**Consultation Response from KC,
Highways Development Management**
2020/94256 Highfield House, Clough Road, Flockton, Huddersfield, WF4 4AQ
Conversion of barn and single storey extension to create one dwelling
**Date Responded:
04/02/201**
**Responding Officer: Zack
Turner**
Responding Ref: 17-34-2

This application is at Highfield House, Clough Road, Flockton, Huddersfield. The proposal is for the conversion of the barn and single storey extension to create one dwelling.

Dwg.no 02a

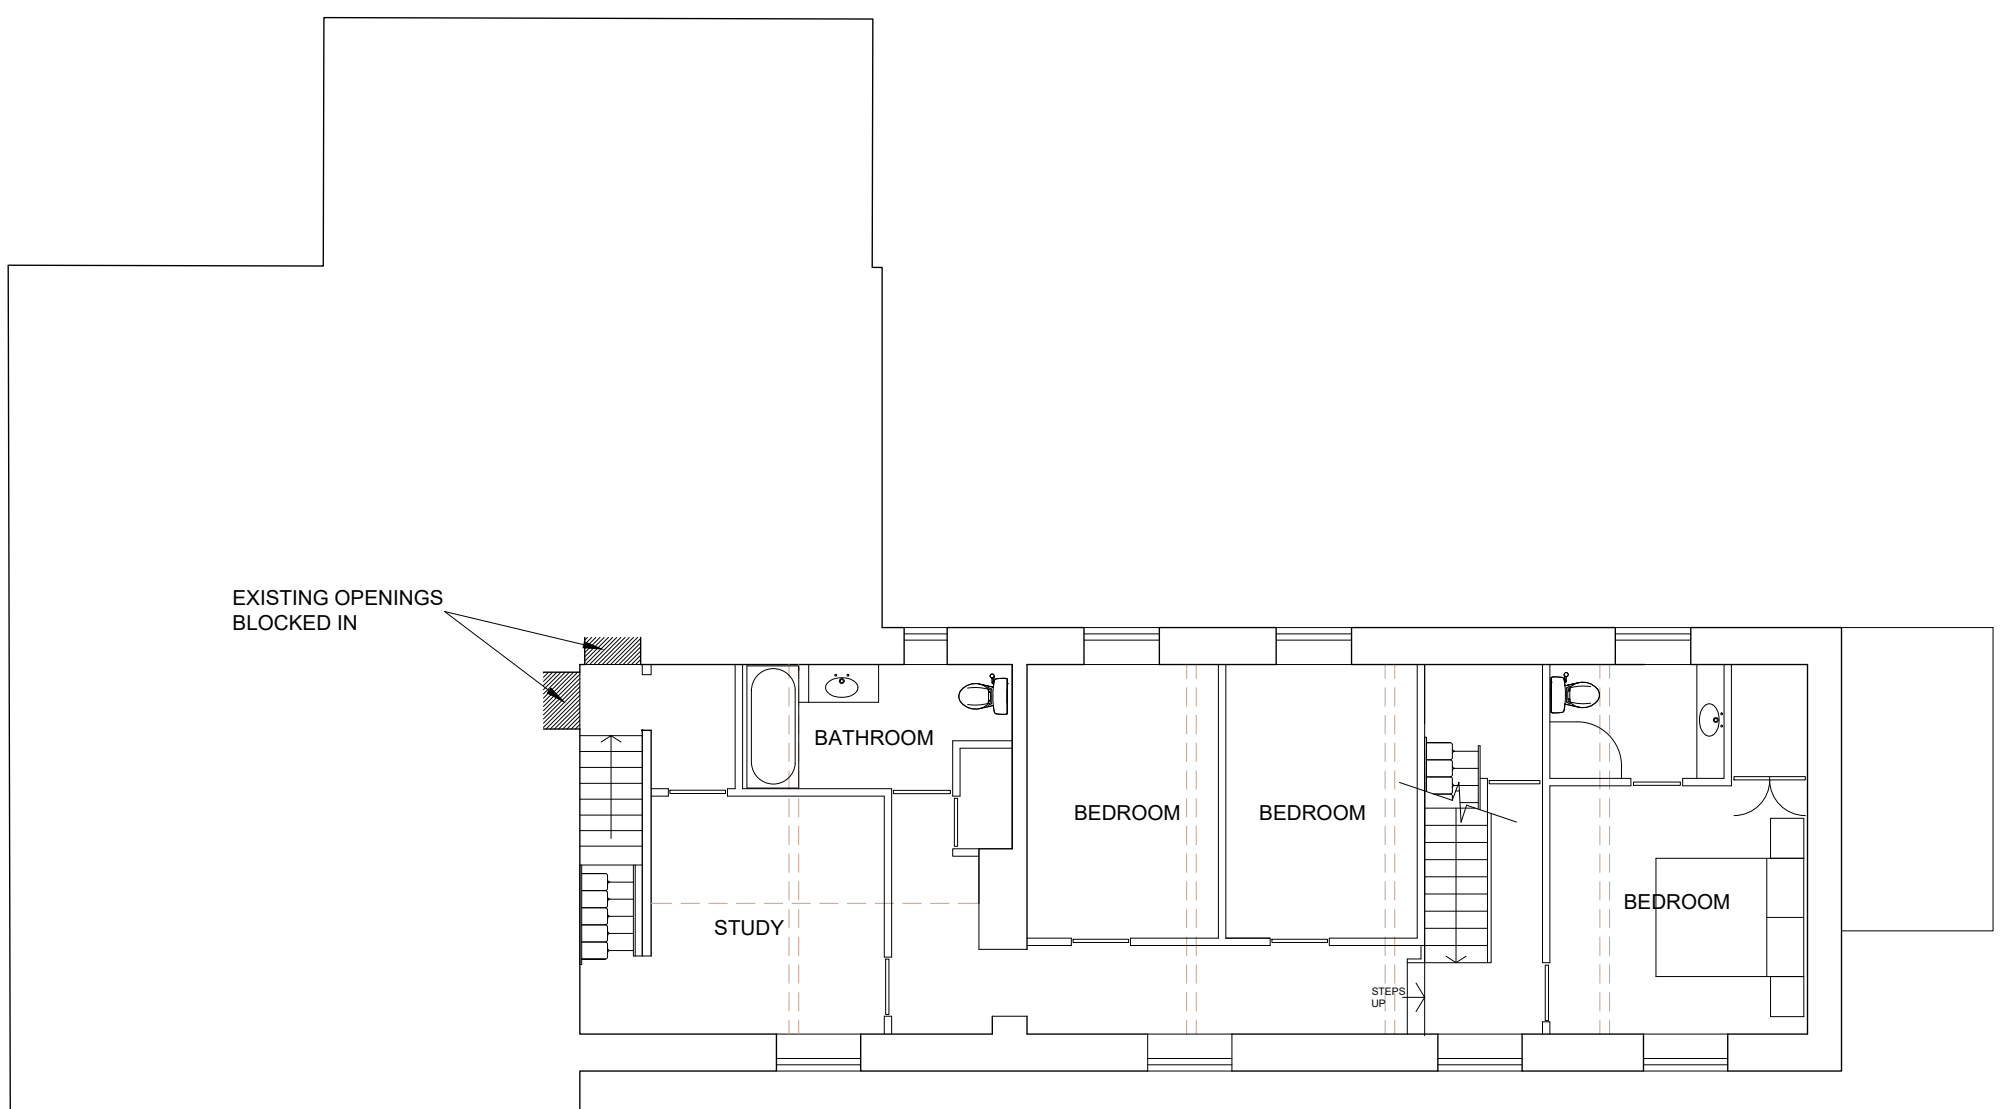
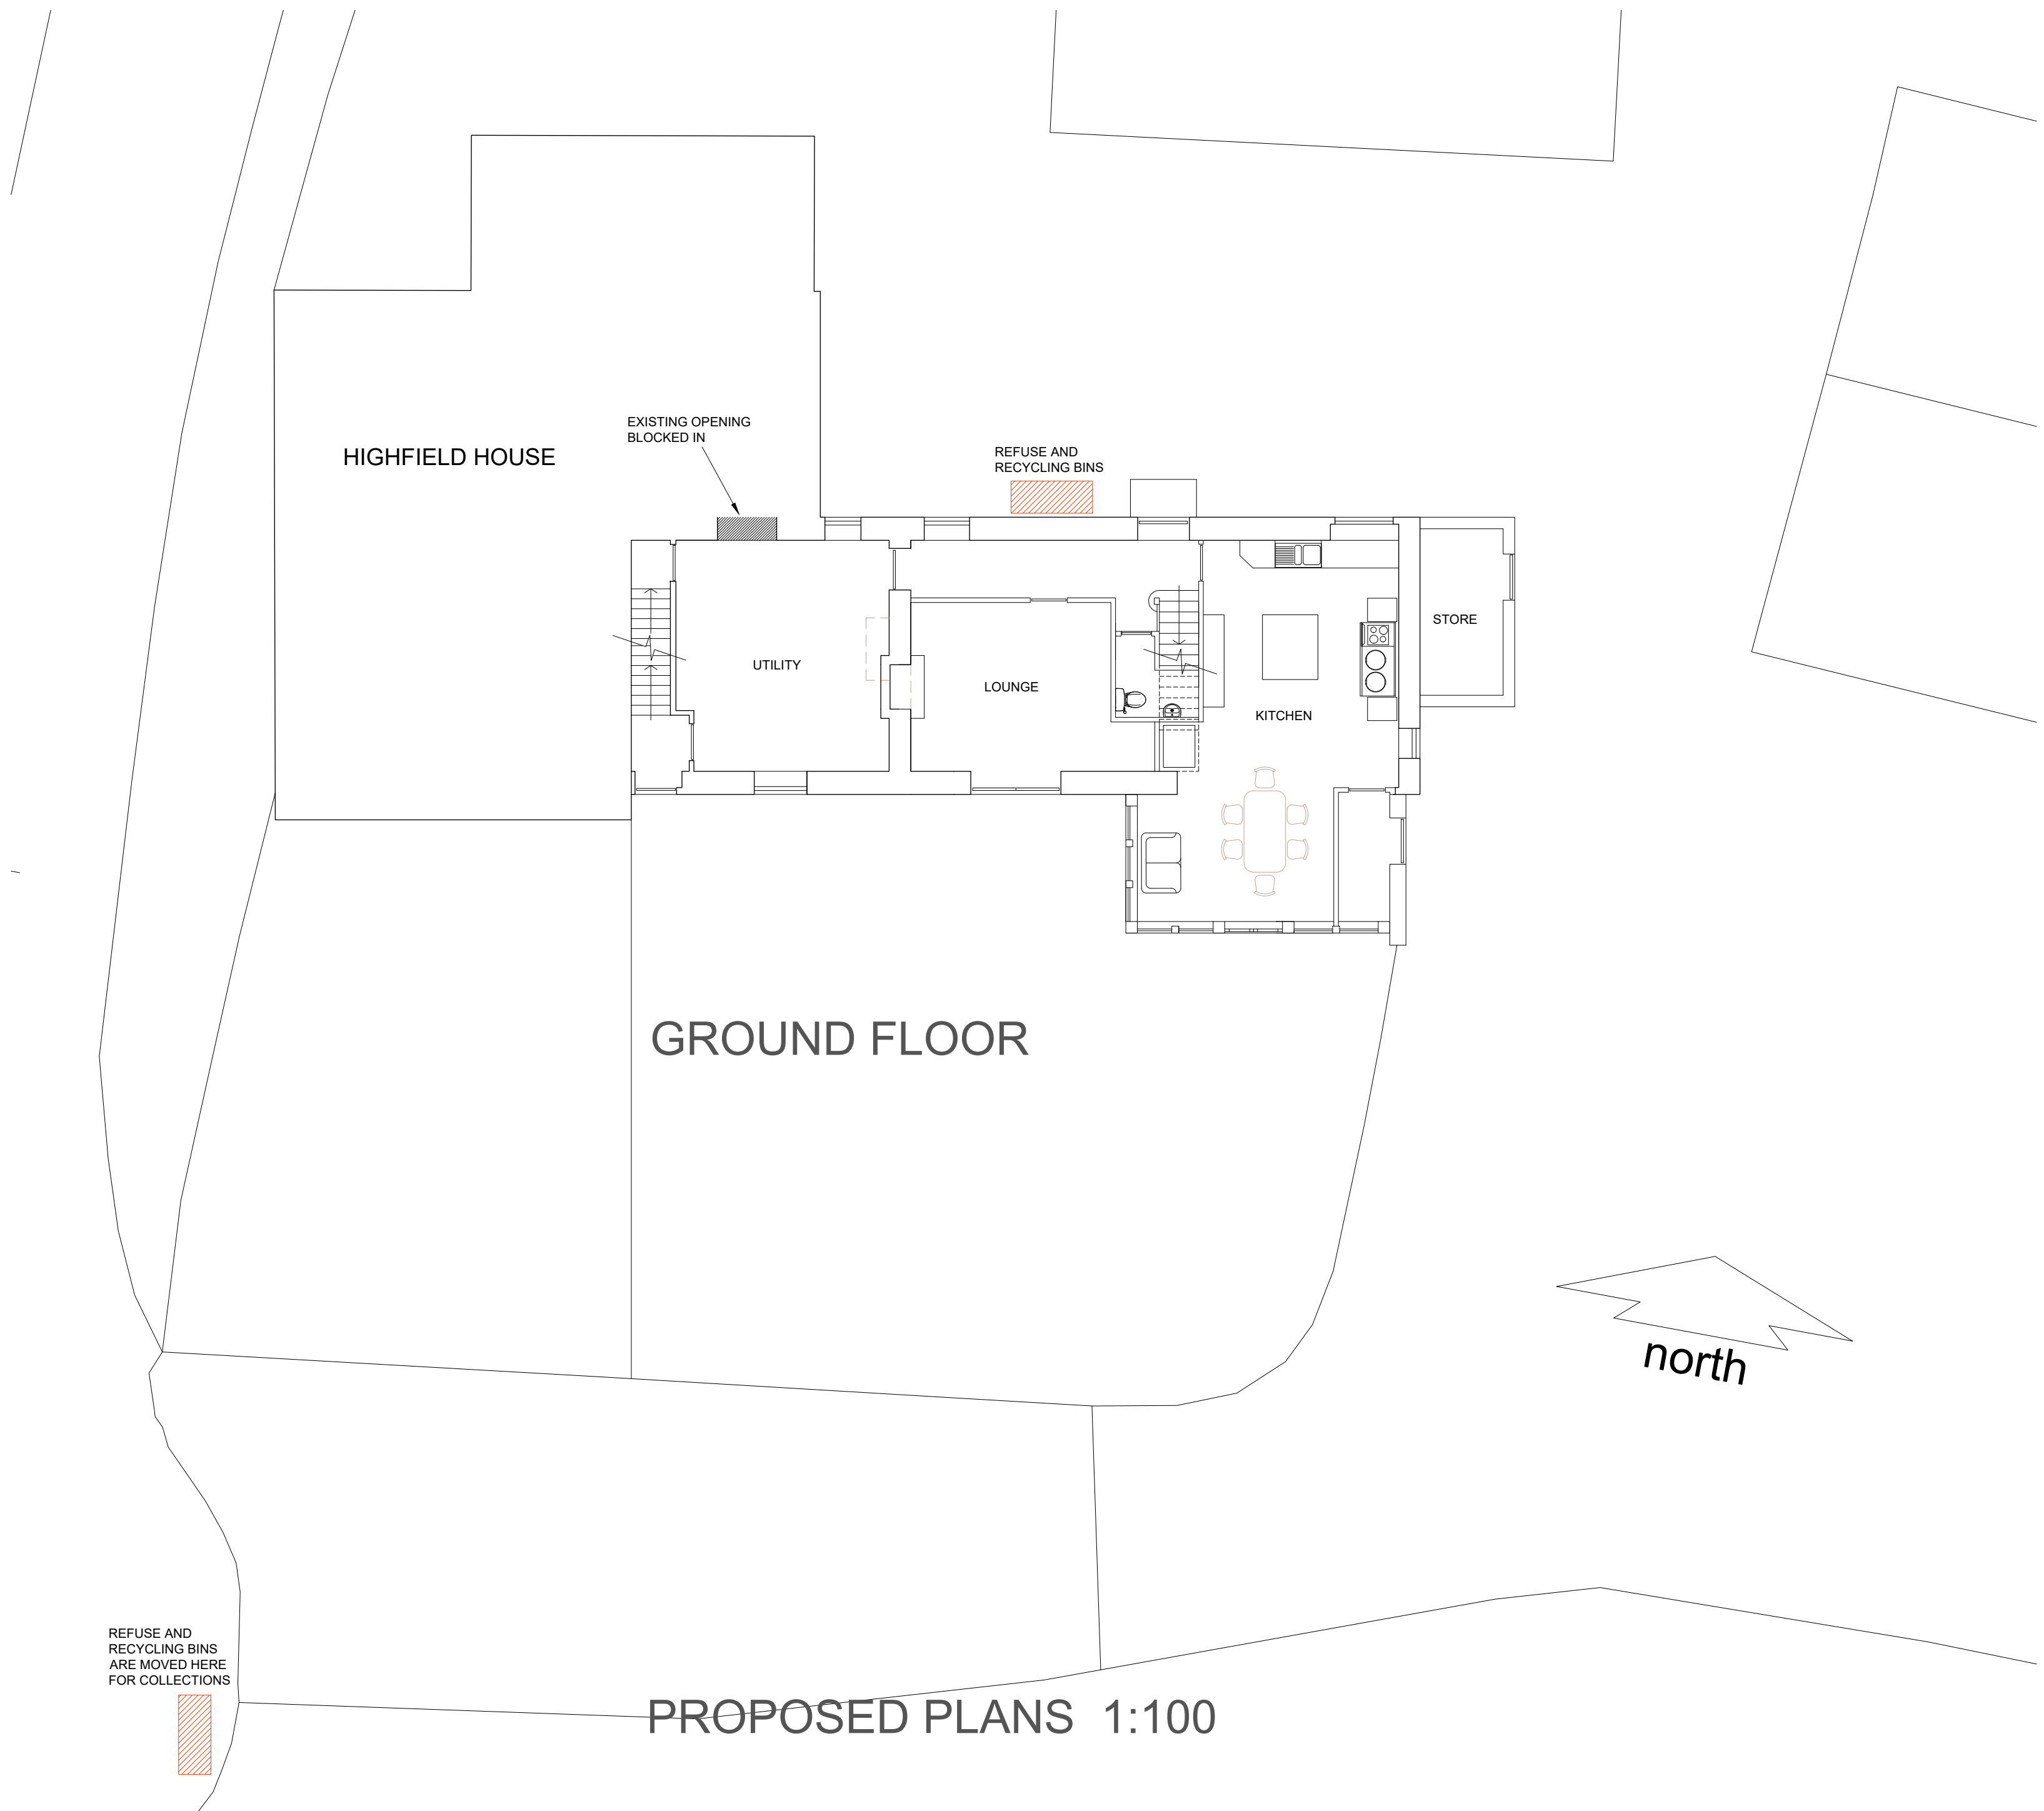
No details have been provided for bin storage and HDM requests that this is clearly shown on a drawing. If the information can be provided prior to determination, then the condition can be removed.
